**Response to Comments**

Project Name: 163 RV Storage  
 Project File Number: PA23-016 - Technical Review 2  
 Review Completion: March 5, 2024

**CIVIL SITE PLAN**

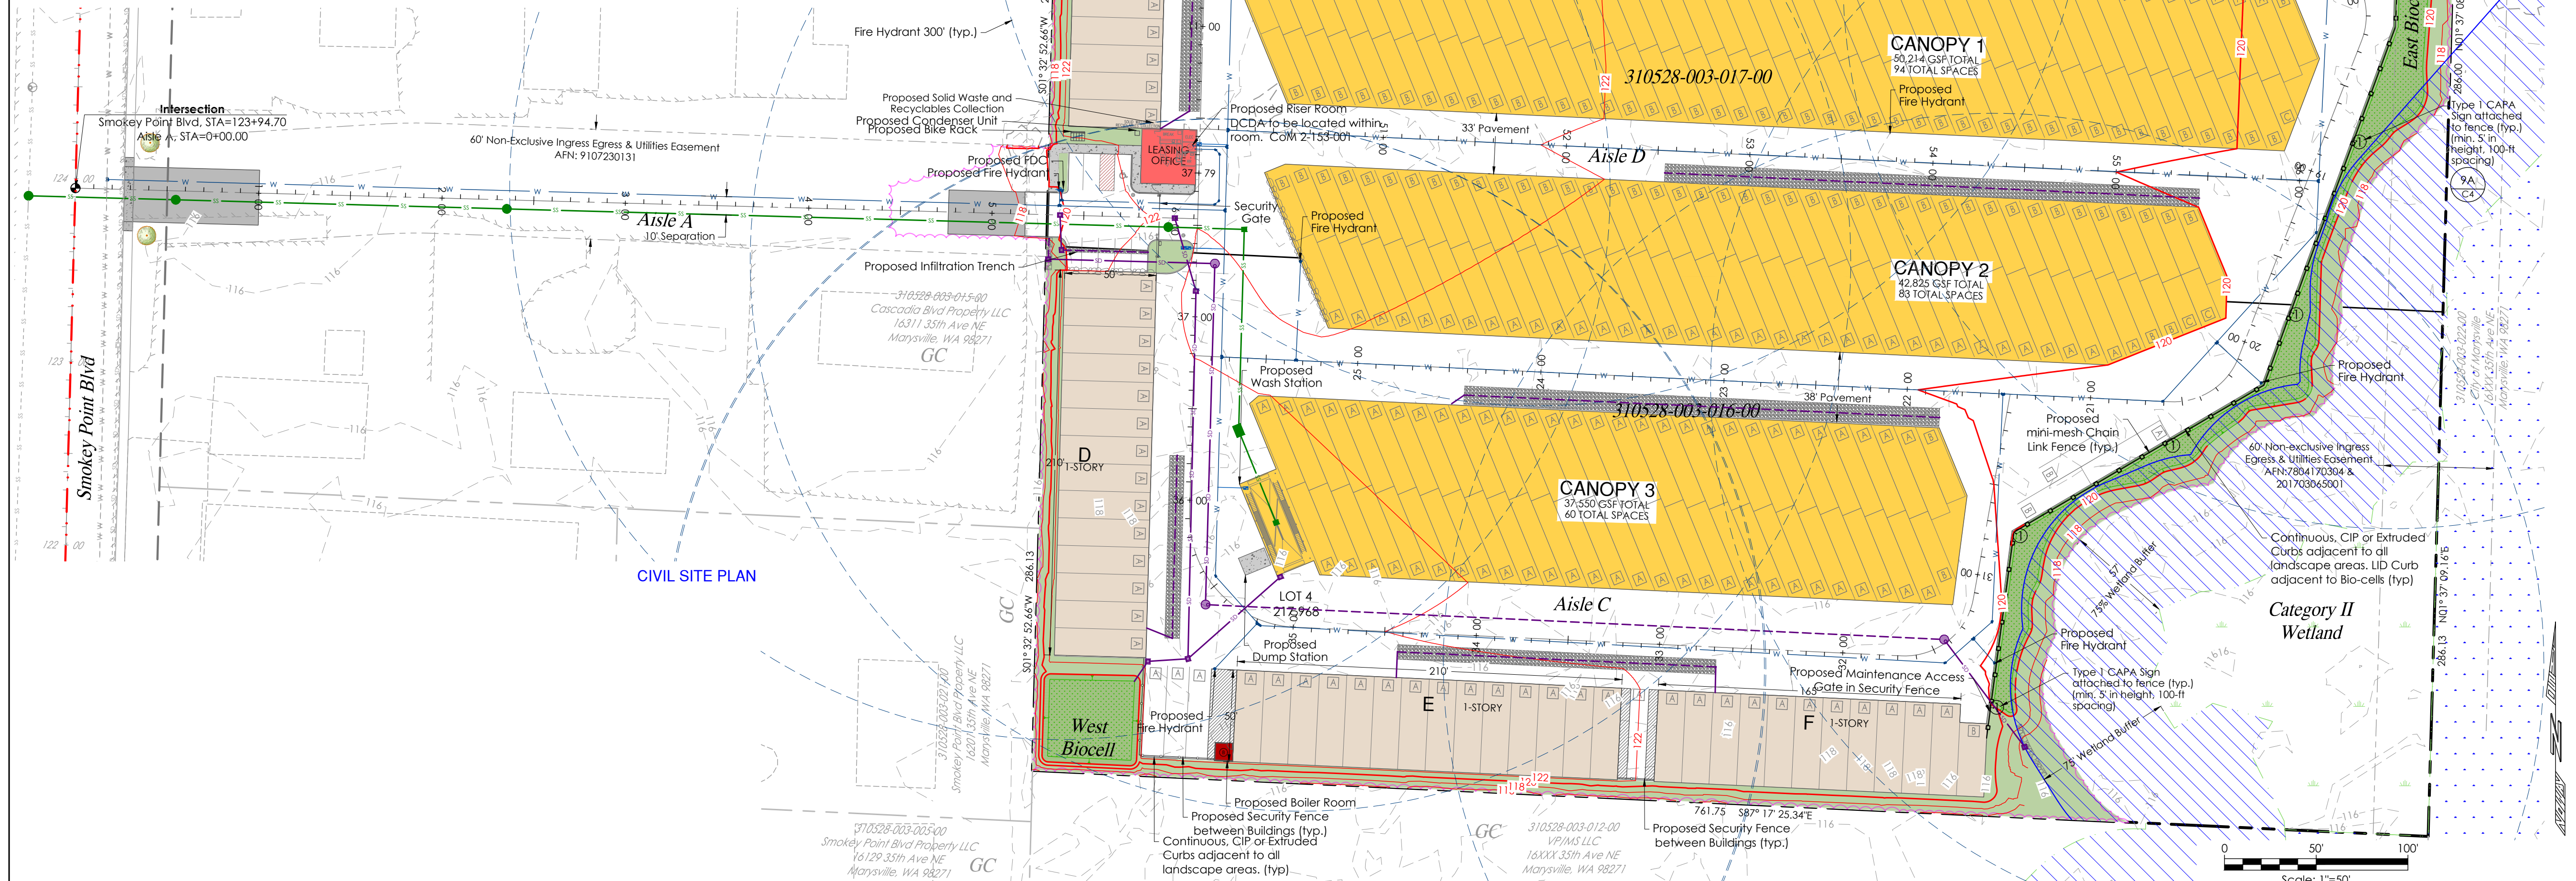
2. Provide specifications for the proposed security fence. The plans currently do not provide the proposed height or material proposed	The specifications have been added on C1.

1. Per Design and Construction standards 2-060 part D #4, hydrant assemblies within a commercial setting spacing shall not exceed 300'.	Fire hydrant 300' circles have been added on C1.
<p><b>Public Works:</b>  Reviewer: Ryan Carney, Surface Water Inspector</p>

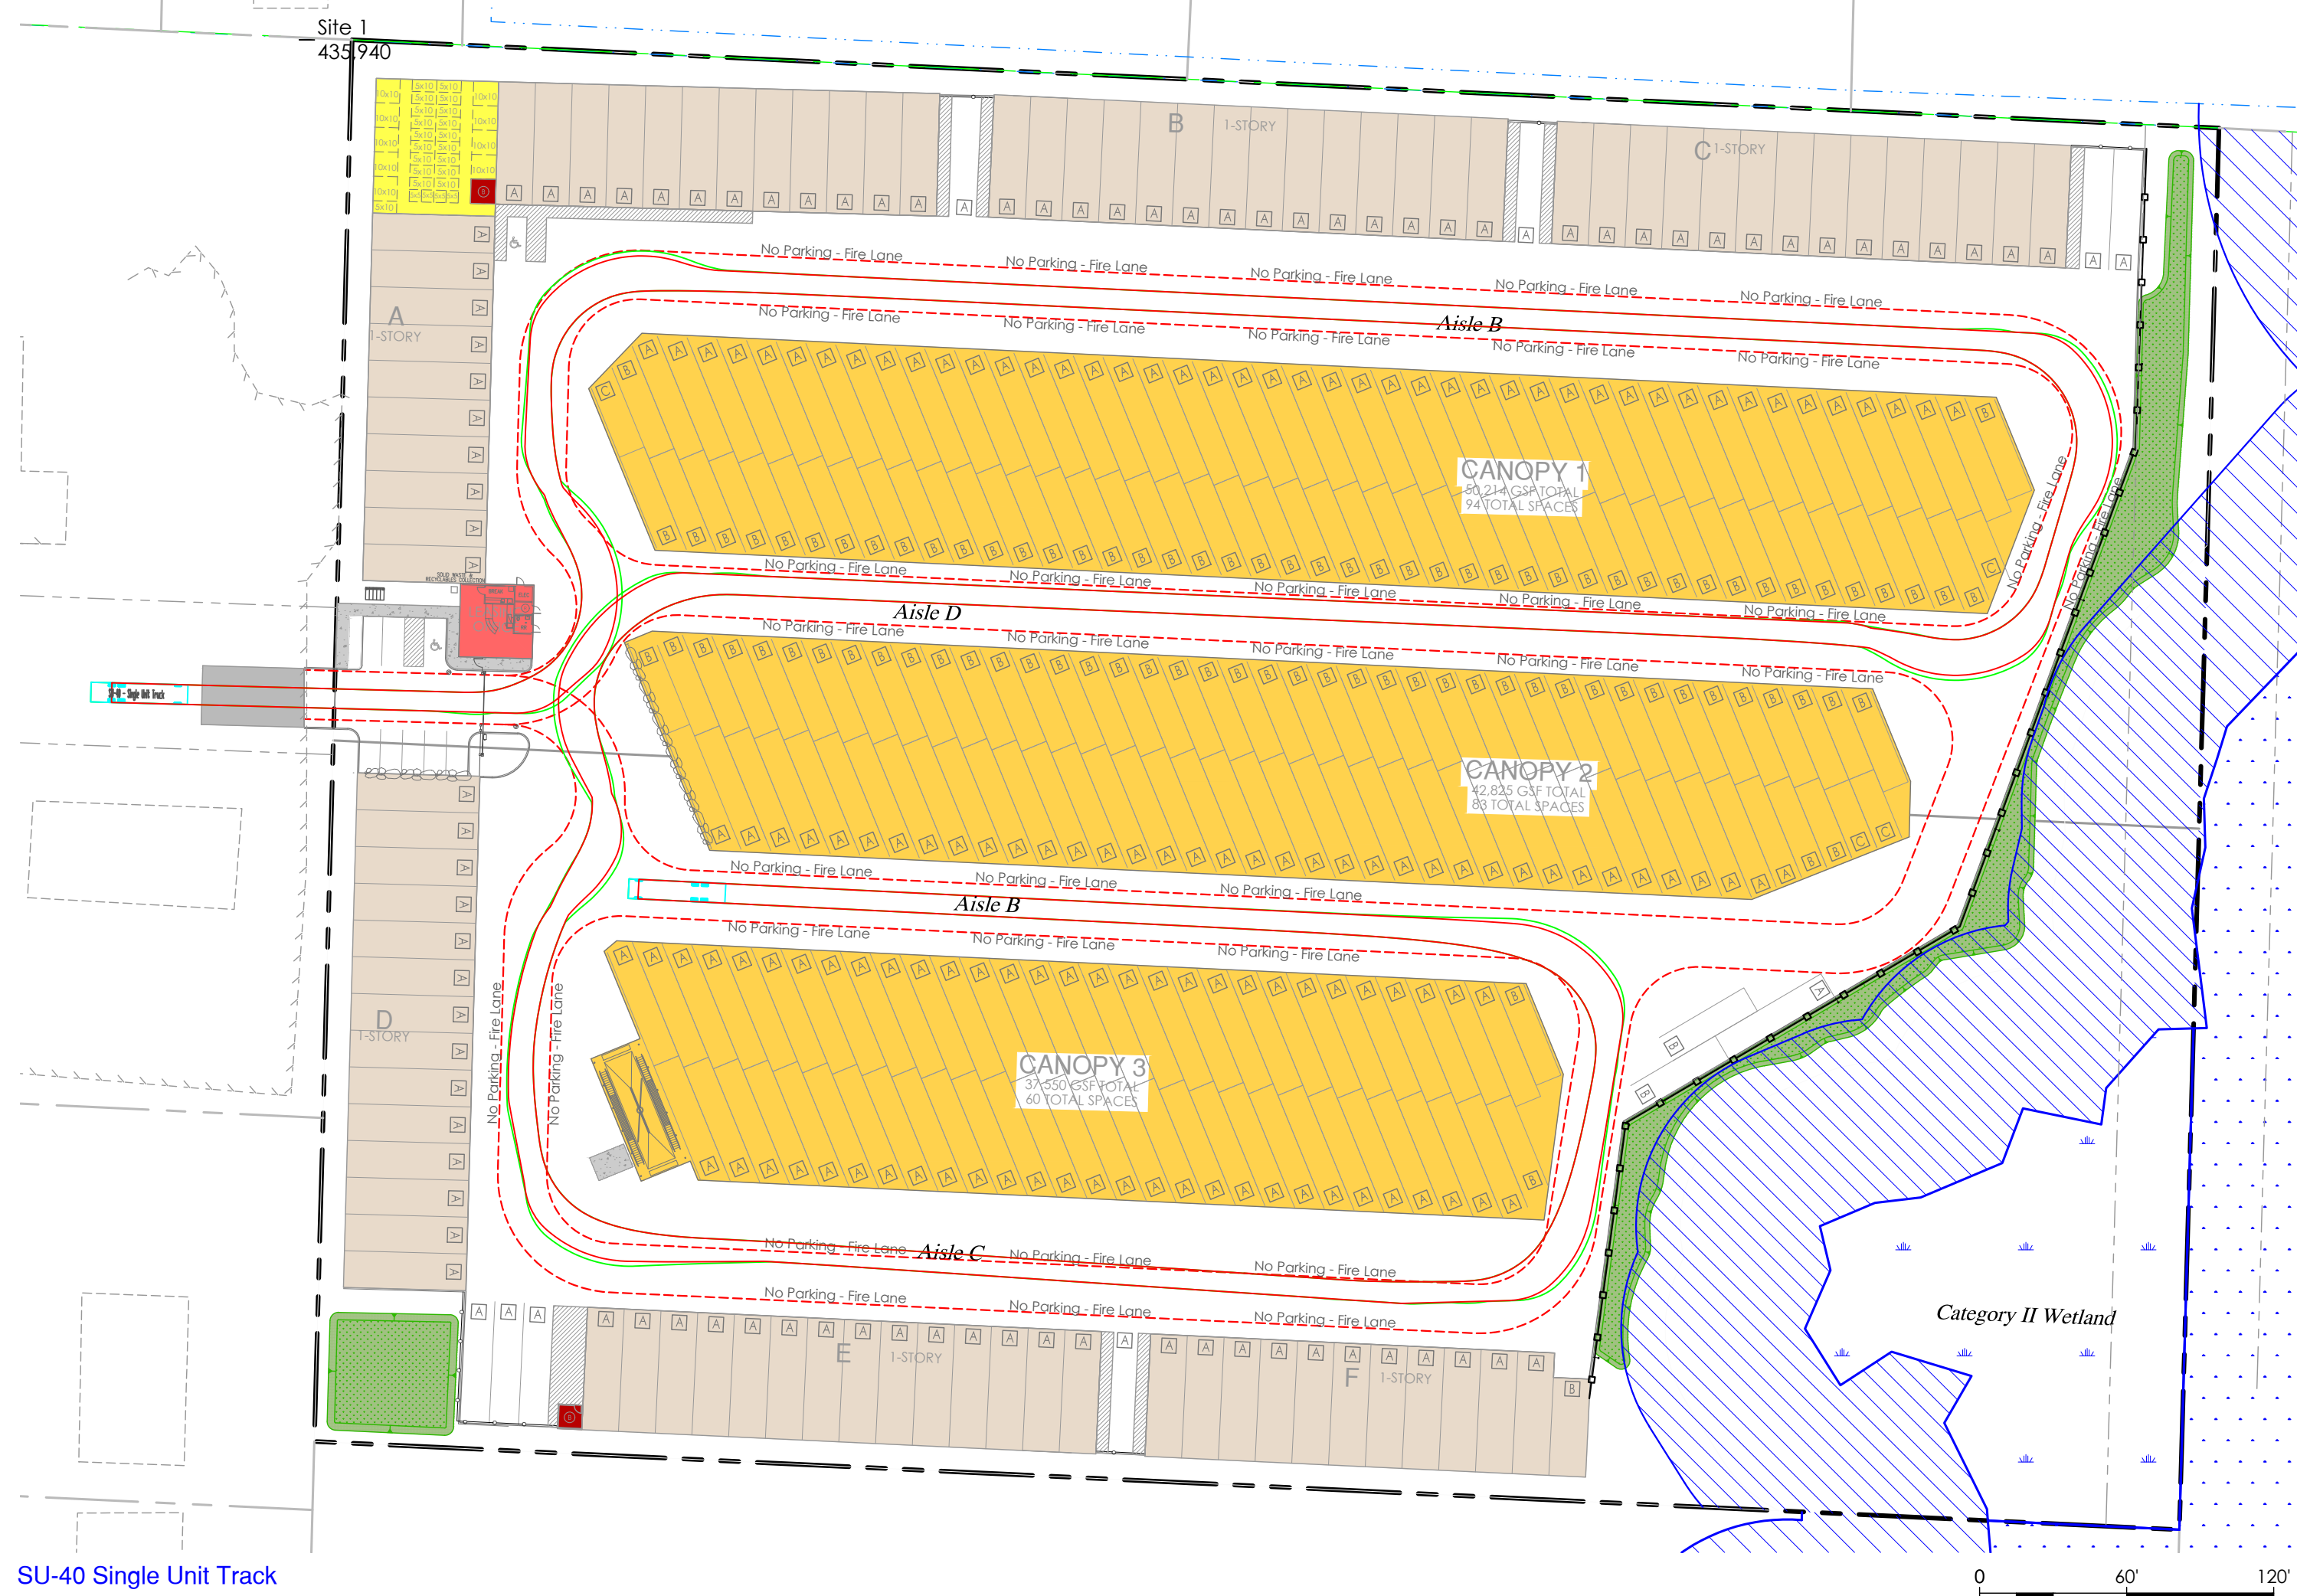
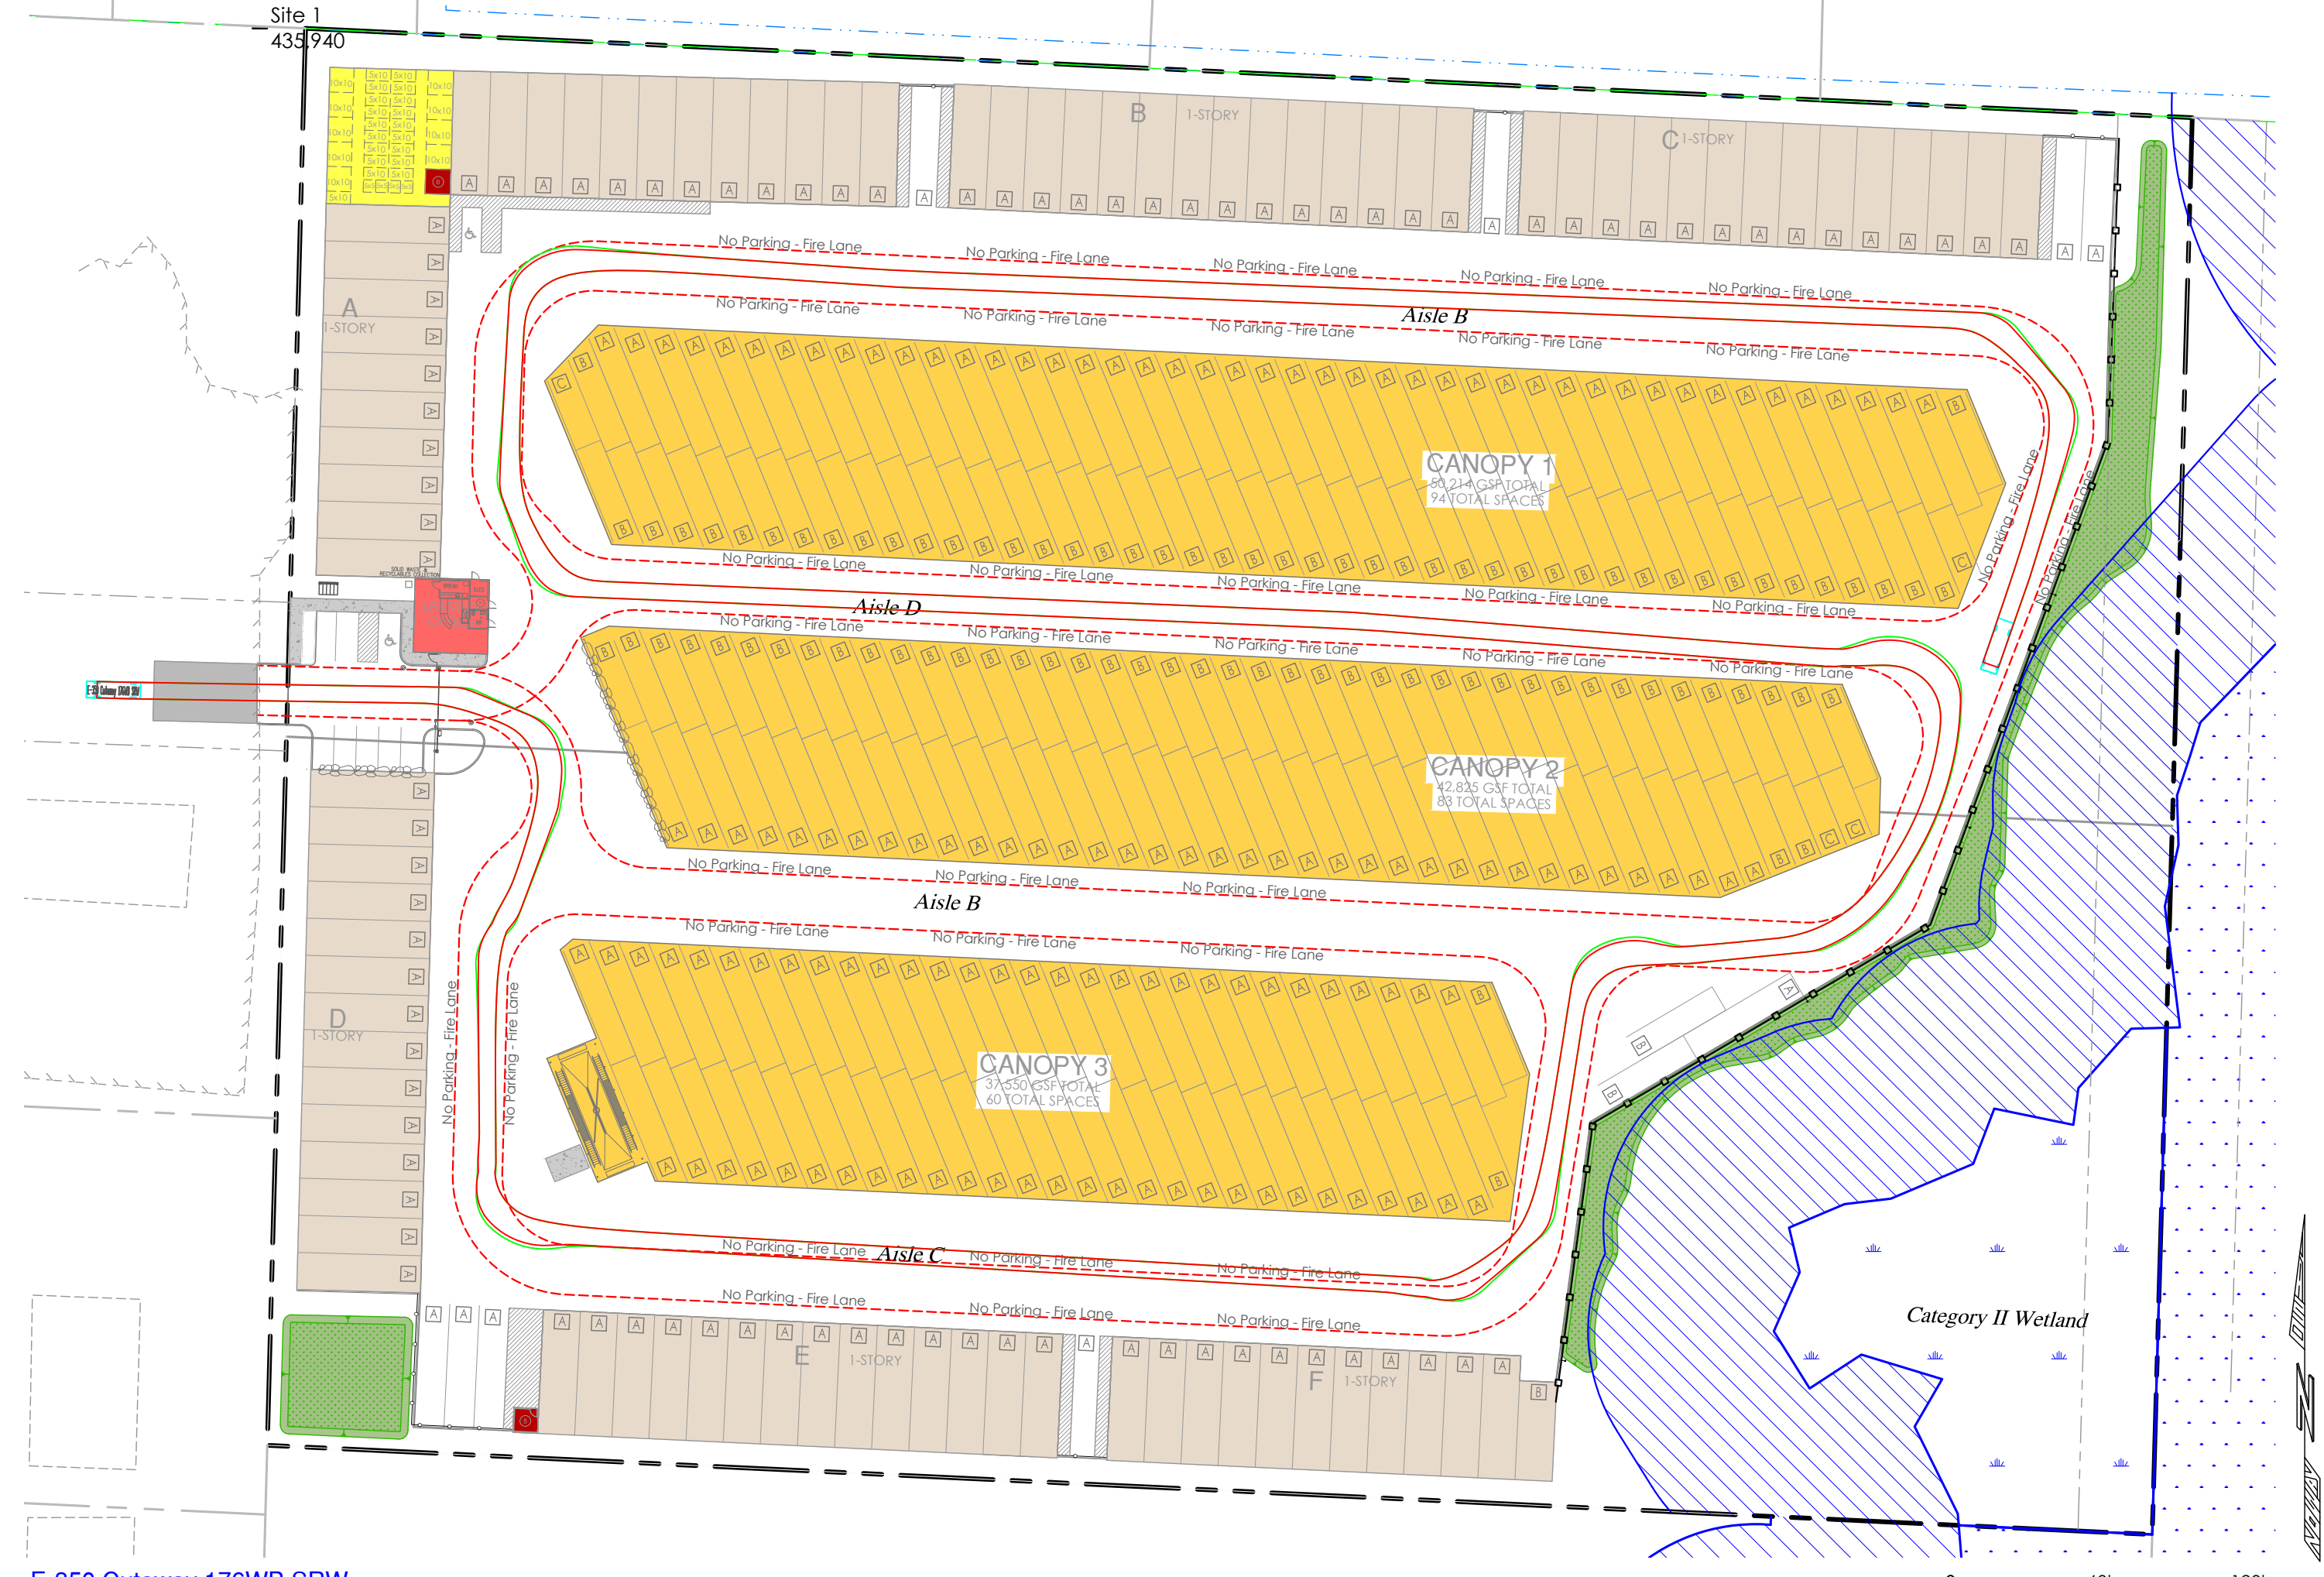
9. Recommend the roadways be posted "FIRE LANE - NO PARKING" to maintain unobstructed emergency access.	Fire Lane markings will be provided through site to demonstrate clear fire lane through pavement. See Sheet C20 for autoturn analysis and fire lane markings
